Appendix D

Detailed Response to Submissions

1.1 Department of Planning, Housing and Infrastructure

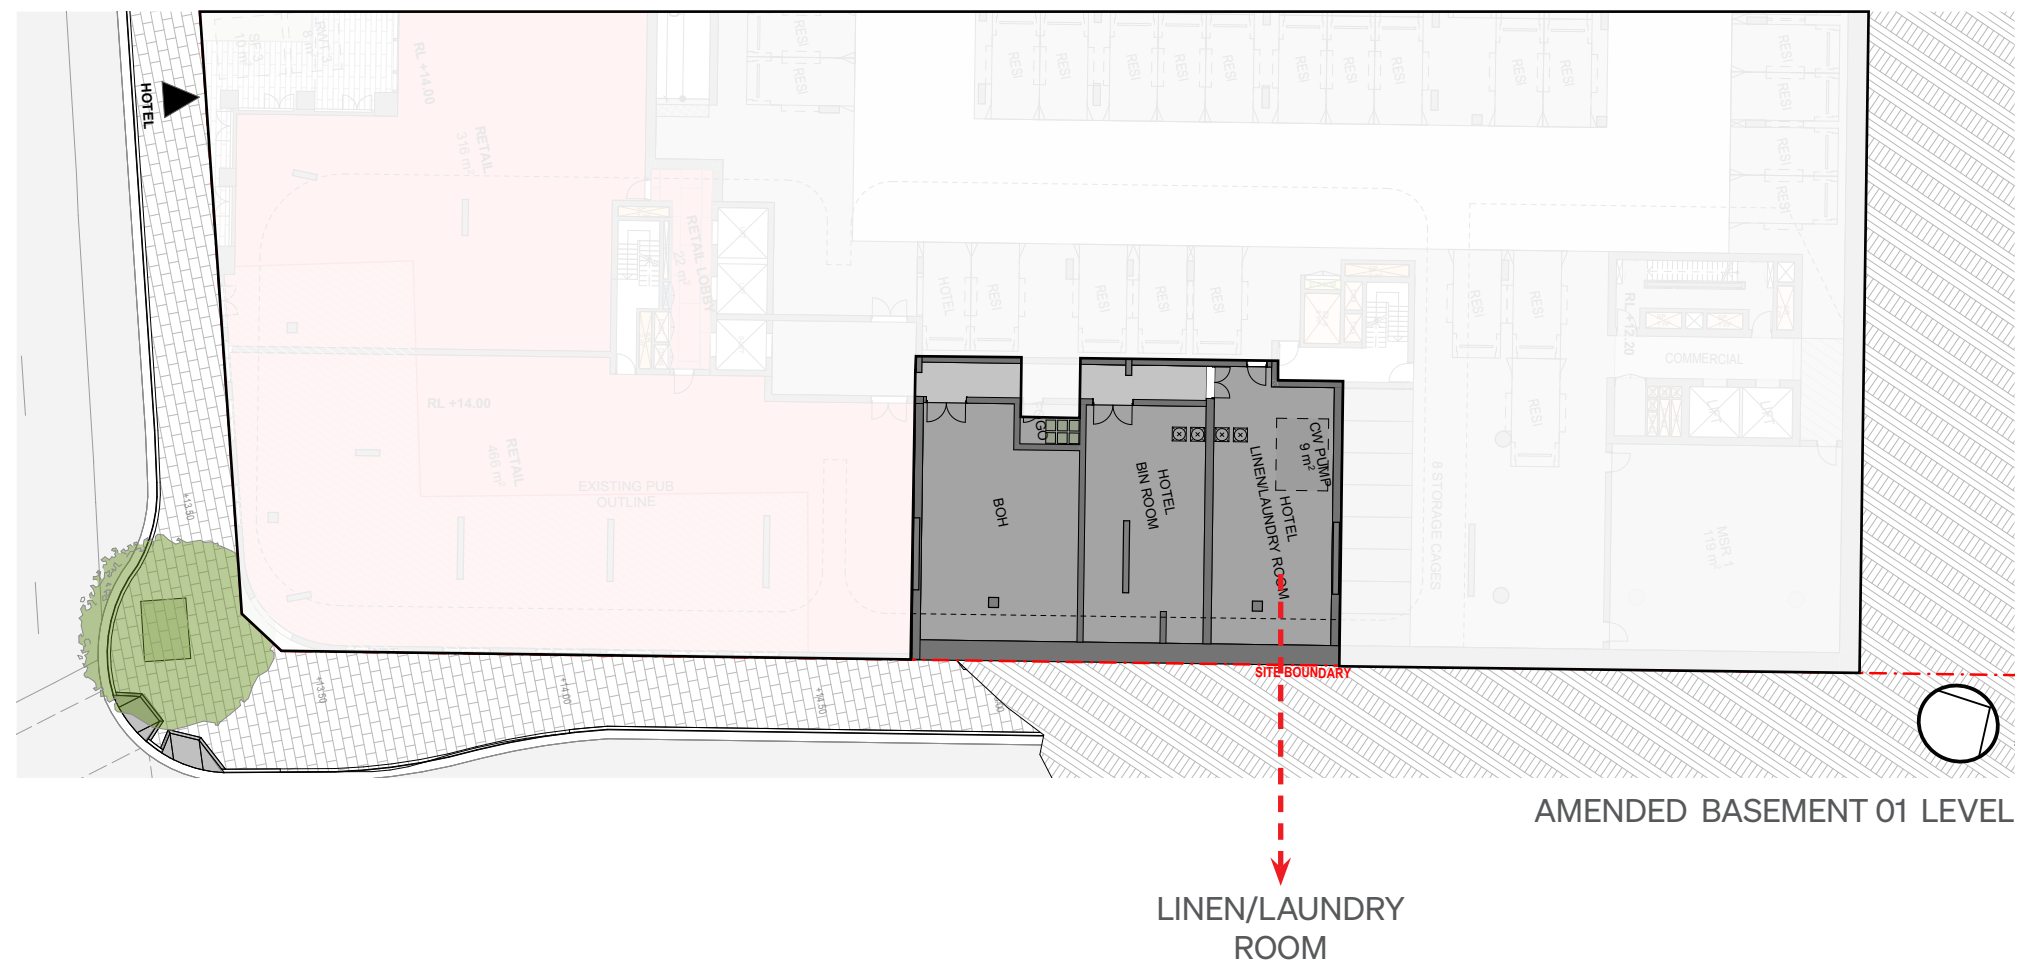
Miscellaneous		
DPHI-26	<i>Clarify if the hotel will be provided with an on-site laundry service of sufficient capacity to service the development. If no laundry is provided, detail how the hotel will be serviced, update the plans and traffic and loading assessments accordingly.</i>	The Architectural Drawings at Appendix E have been updated to clarify that the hotel will be provided with an on-site laundry service at eastern boundary of Basement 01, for further details see Drawing Number DA2001.
DPHI-27	<i>Detail how the various uses within the site will be coordinated including the maintenance and management of all publicly accessible spaces including the through-site links and communal open space.</i>	Refer to the Plan of Management lodged with the SSDA submission at Appendix RR. A final plan of management can be secured via condition of consent.
DPHI-28	<i>Clarify that adequate services can be provided to the commercial and retail tenancies based on their anticipated future use, this should include any mechanical ventilation needed to service a food and drink premises.</i>	An Infrastructure Delivery, Management and Staging Plan at Appendix X has been prepared to provide preliminary clarification that adequate services can be provided to the proposed commercial and retail tenancies. Services connections details will be provided at a future stage.
